**From:** [Kelly Bacon \(CD\)](#)  
**To:** ["Dude Moon Pratt"](#)  
**Cc:** [Cameron Curtis](#); [Josh Fredrickson](#)  
**Subject:** FW: VA-20-00013 Pratt - Additional Information  
**Date:** Thursday, April 1, 2021 1:32:36 PM

**Subject:** RE: VA-20-00013 Pratt - Additional Information

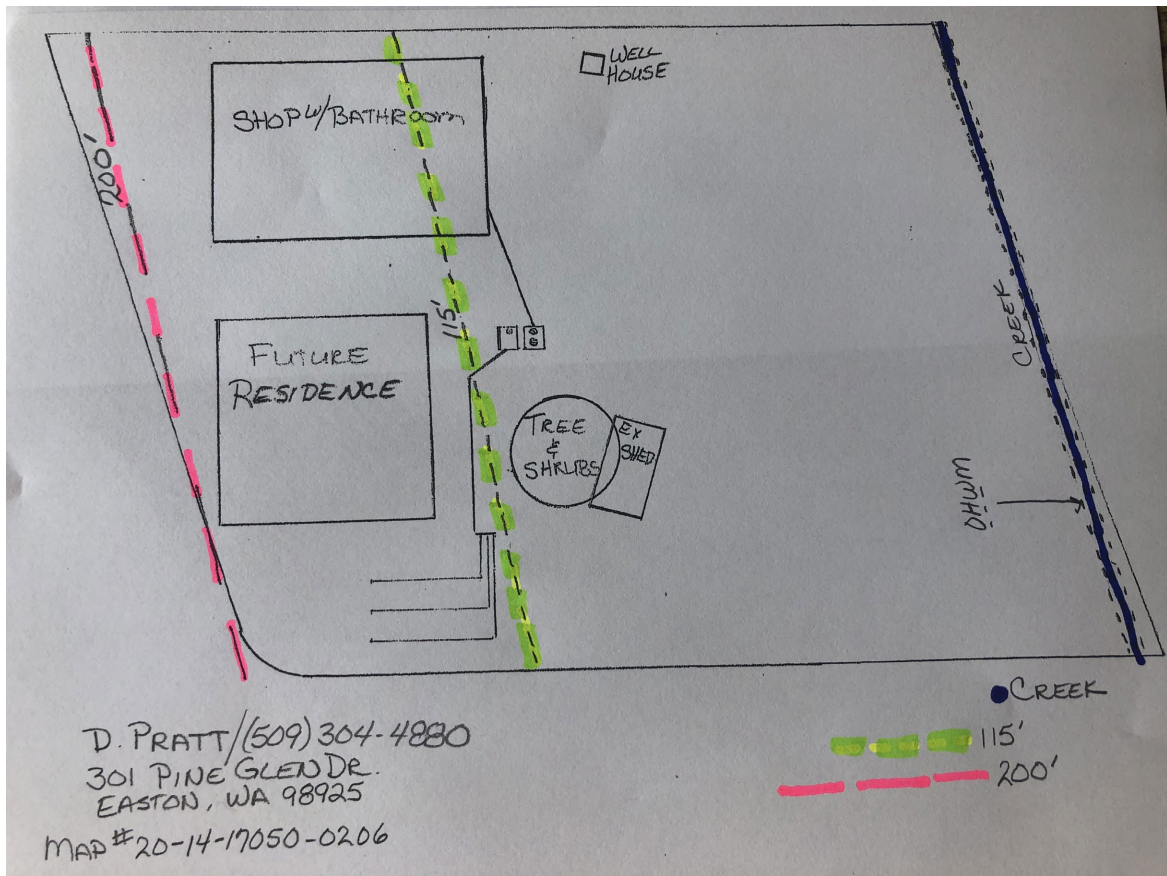
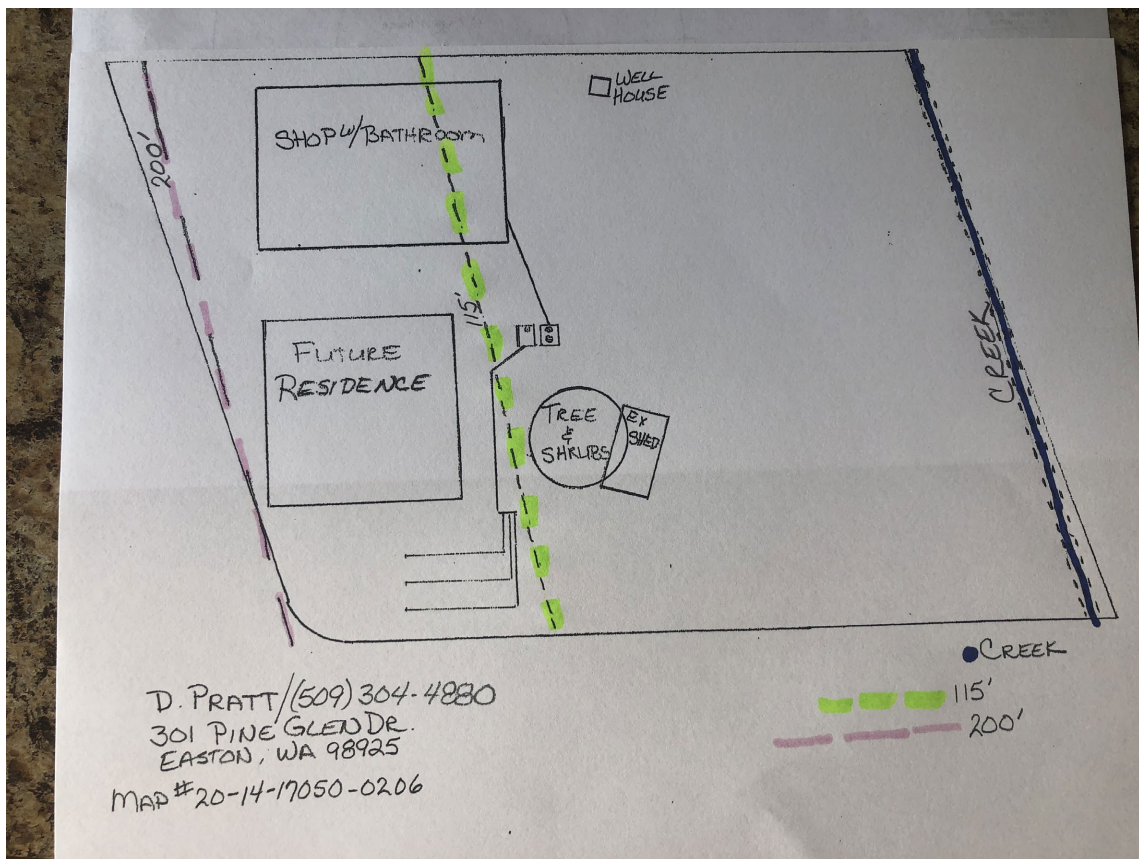
1. Based on the updated site plan, it appears that the structure could be moved so that the corner of the residence is more than 1-ft from the property corner. Public Works is not supportive of a variance to allow 1-ft setback. Public Works' concern is related to future conditions where a 1-ft set back may become an issue. Cameron Curtis and Josh Fredrickson are both happy to meet with the applicant to talk through potential issues. In this situation Public Works would be comfortable with a minimum 5-ft setback, but the applicant should make every effort to increase this set back distance as much as possible.

Cameron Curtis provided comment C, so I am looping Cameron and Josh into this e-mail. The concern identified in comment C is that a 1 foot setback against the property line is not sufficient given potential conflict with future development of the private road intersection. Based on the information provided in the original application, PW opposed a variance which allowed a building to be placed within a foot of the property line. Josh or Cameron will need to review the additional information provided by the applicant (I've attached the updated site plan and the applicant's response to comments) to determine if their concerns have been addressed.
